Our ref: HA/2019/121410/01-L01
Your ref: EG/16/19/HH
Date: 03 July 2019

QUERY REGARDING INFORMATION REQUIRED -TWO STOREY EXTENSION

49 WARREN WAY BARNHAM PO22 0JX

Title
SITE & BLOCK PLANS

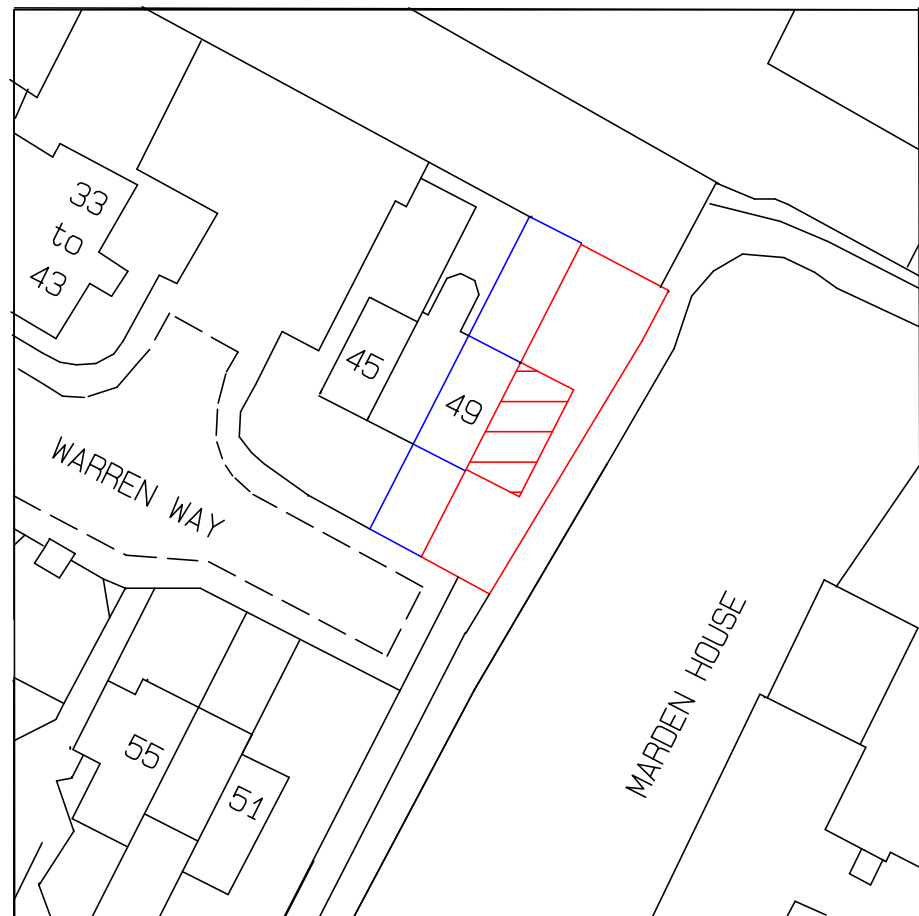
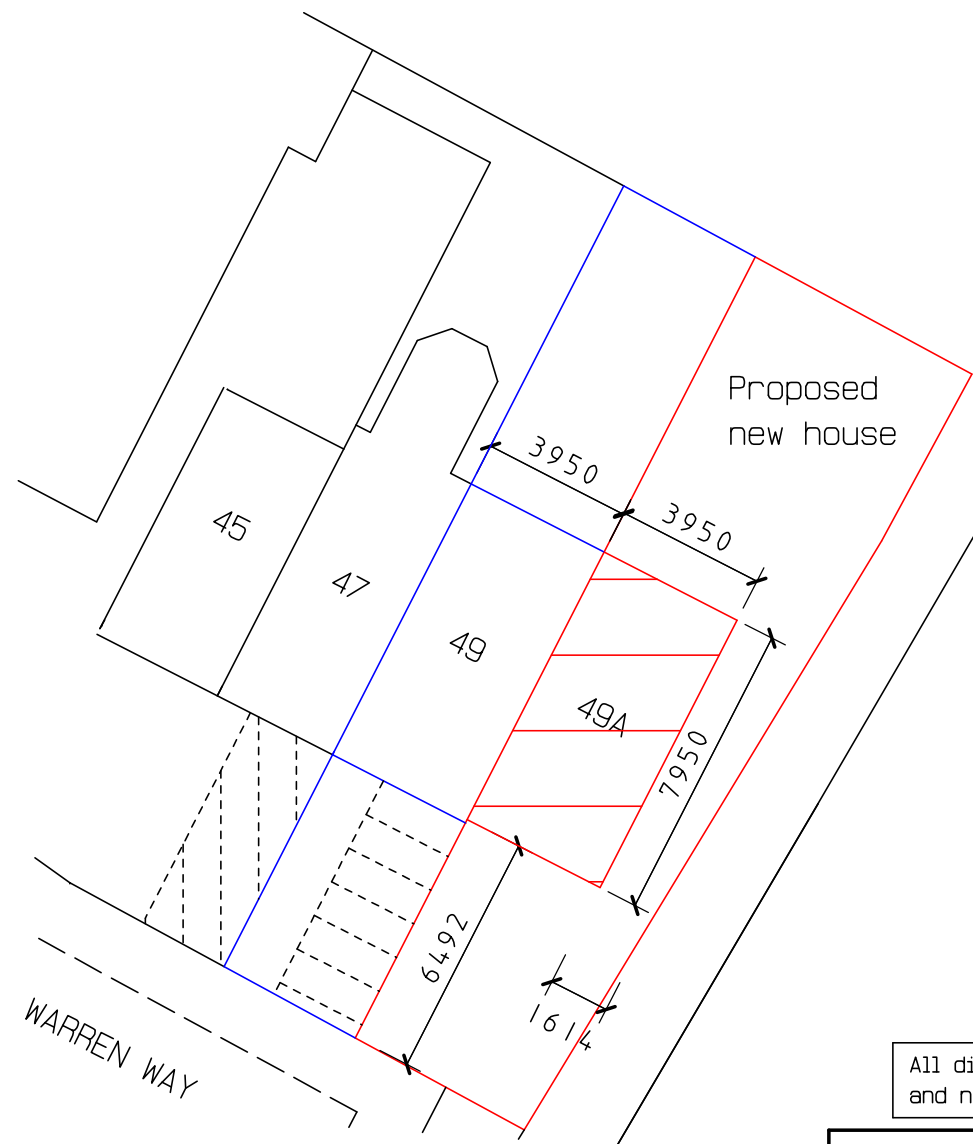
The boundary of the proposed extension will have a distance of 1.6m from a main river (Barnham Rife). Previous objections were due to uncertainties of a FRAP being issued as we had insufficient details of foundations, therefore raising concerns on the stability of the bank. However, the applicant has now submitted further details relating to building foundations, which has helped us in advising what we would need at the FRAP application stage.

The boundary of the proposed extension will have a distance of 1.6m from a main river (Barnham Rife) with previous objections relating to uncertainties of a Flood Risk Activity Permit (FRAP) being issued. This was due to concerns relating to the stability of the bank due to insufficient details of foundations under the proposed extension being supplied.

- Accurate measurements of the foundation piling that show that piling shall reach a lower level than the river bed. We must be satisfied with the bank stability and that the extension will be adequately supported should undercutting of the bank occur
- Precise Drawings/ plans of where material will be stored to ensure no pollutants enter the river
- Photos of the site before works are carried out to ensure both the river and the bank have been returned to their previous state after works are completed

Title PROPOSED FLOOR PLANS	Client Mr Ben Matthews
Project PROPOSED NEW END OF TERRACE TWO STOREY TWO BEDROOM DWELLING @ 49 WARREN WAY BARNHAM WEST SUSSEX PO22 0JX	Drawn by R Hollands (GROVE DESIGN UK) Date February 2020 Scale 1:50 @ A3 Drawing No 20-02-GD-243-03A Amendments (A) Planning issue

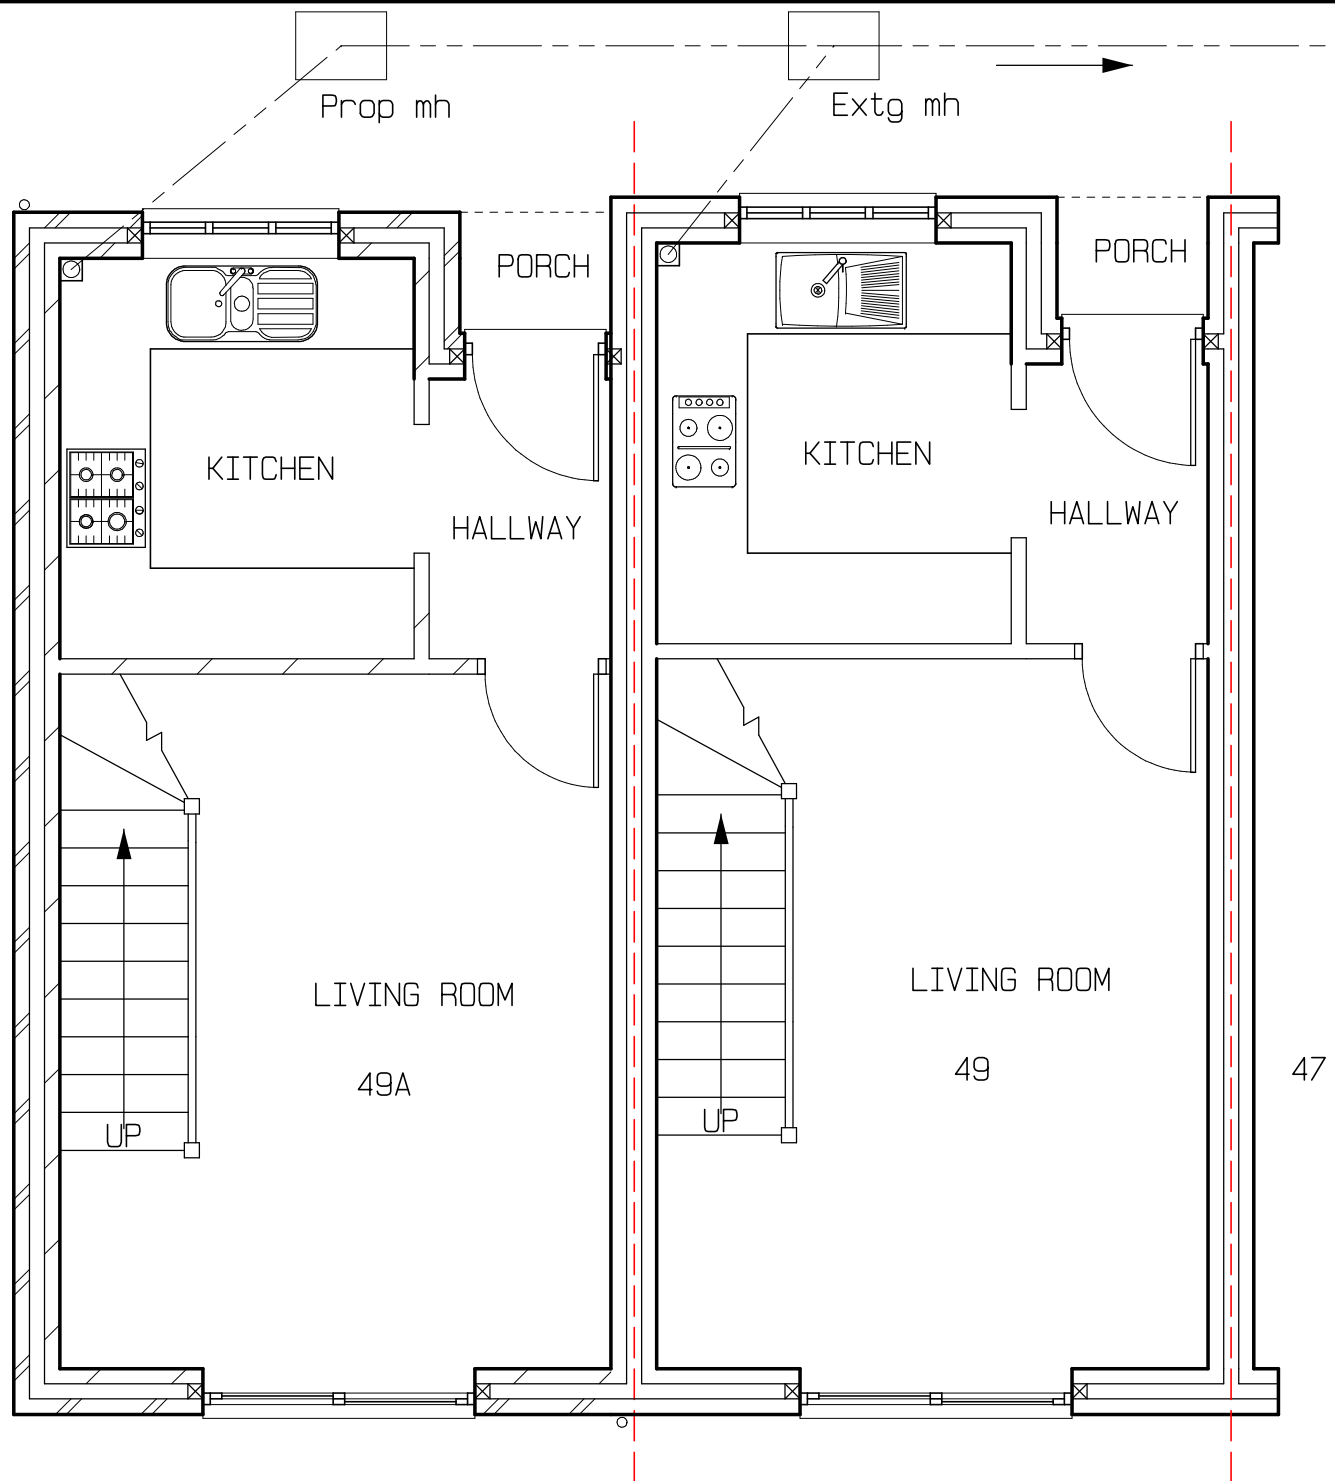
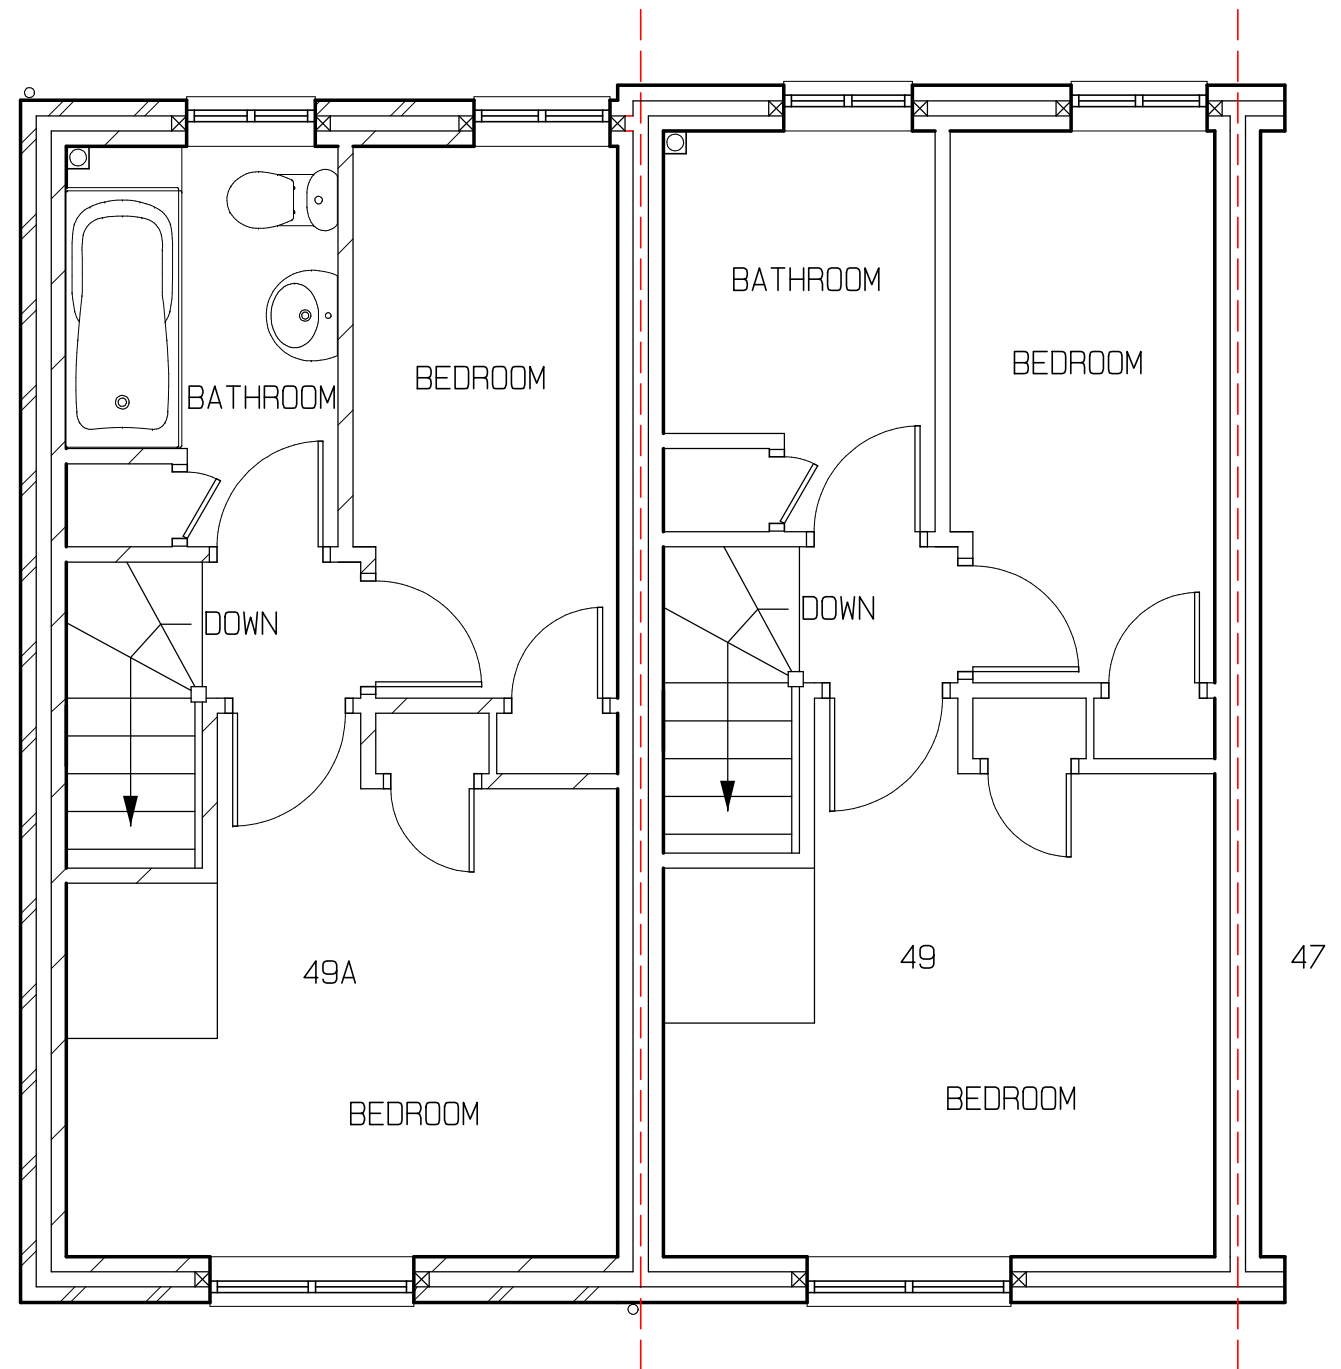
The proposed 2 storey extension falls within flood zone 3 (High Risk) fluvial flooding. Plans show that there will be no sleeping accommodation on the ground floor, therefore occupants will have safe refuge from flood risk. The FRA also states sufficient flood mitigation measures as set out within section 6, which include setting FFL no lower than existing and implementing flood resilient design measures.

- the property
- Flood resilient measures as set out in section 6.2 of the Flood Risk Assessment
- No sleeping accommodation shall be placed on the ground floor
